# KITTITAS COUNTY FIRE MARSHAL'S OFFICE

January 18, 2023

To: Whom It May Concern  
Re: RU-22-00006 Harmon

**1 MITIGATION SITE PLAN**

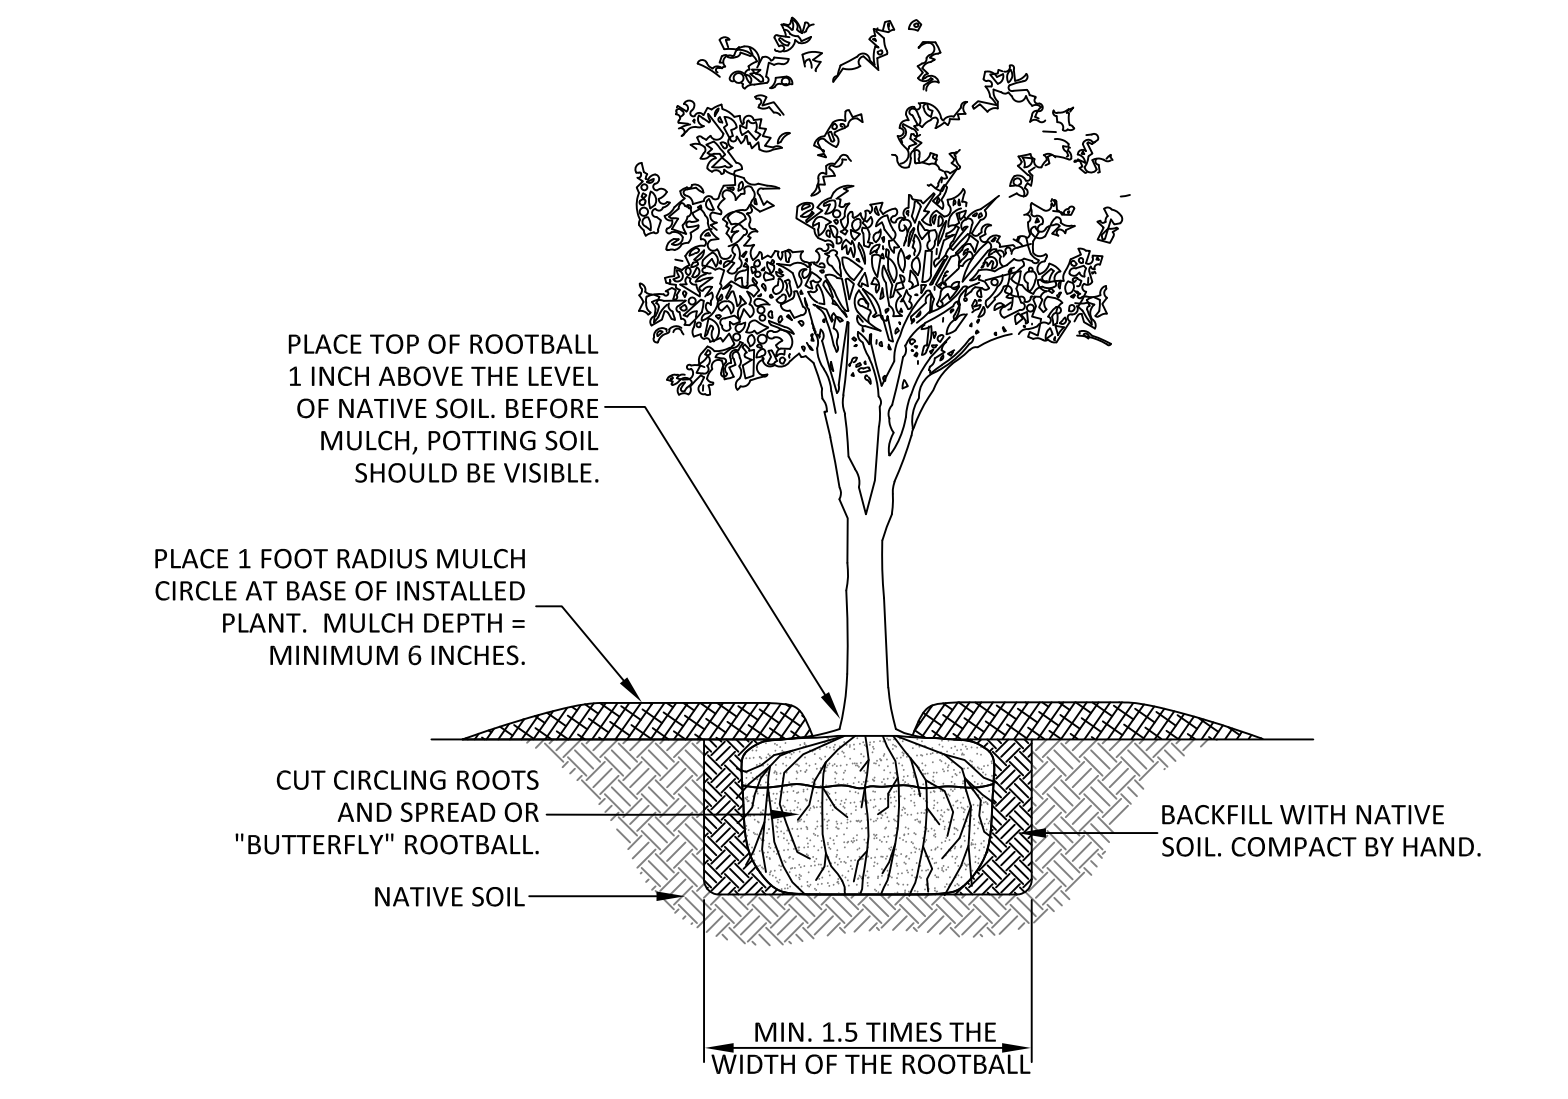
The proposed structure will receive a WUIC Evaluation and be expected to comply with the requirements set therein. A portion of these requirements is a defensible space. The defensible space requirements shall be applied with the greatest detail and shall not be applied to the critical areas buffers any more than absolutely necessary. IWUIC Chapter 202; DEFENSIBLE SPACE. An area either natural or man-made, where material capable of allowing a fire to spread unchecked has been treated, cleared or modified to slow the rate and intensity of an advancing wildfire and to create an area for fire suppression operations to occur.

As the commentary of the 2018 IWUIC states "it is not the intent for the defensible space to be void of vegetation; the vegetation must be thinned and maintained. Trees are allowed within the defensible space, but they are to be removed or trimmed to provide a clear separation of 10 feet from the crown to other trees and to the structure."
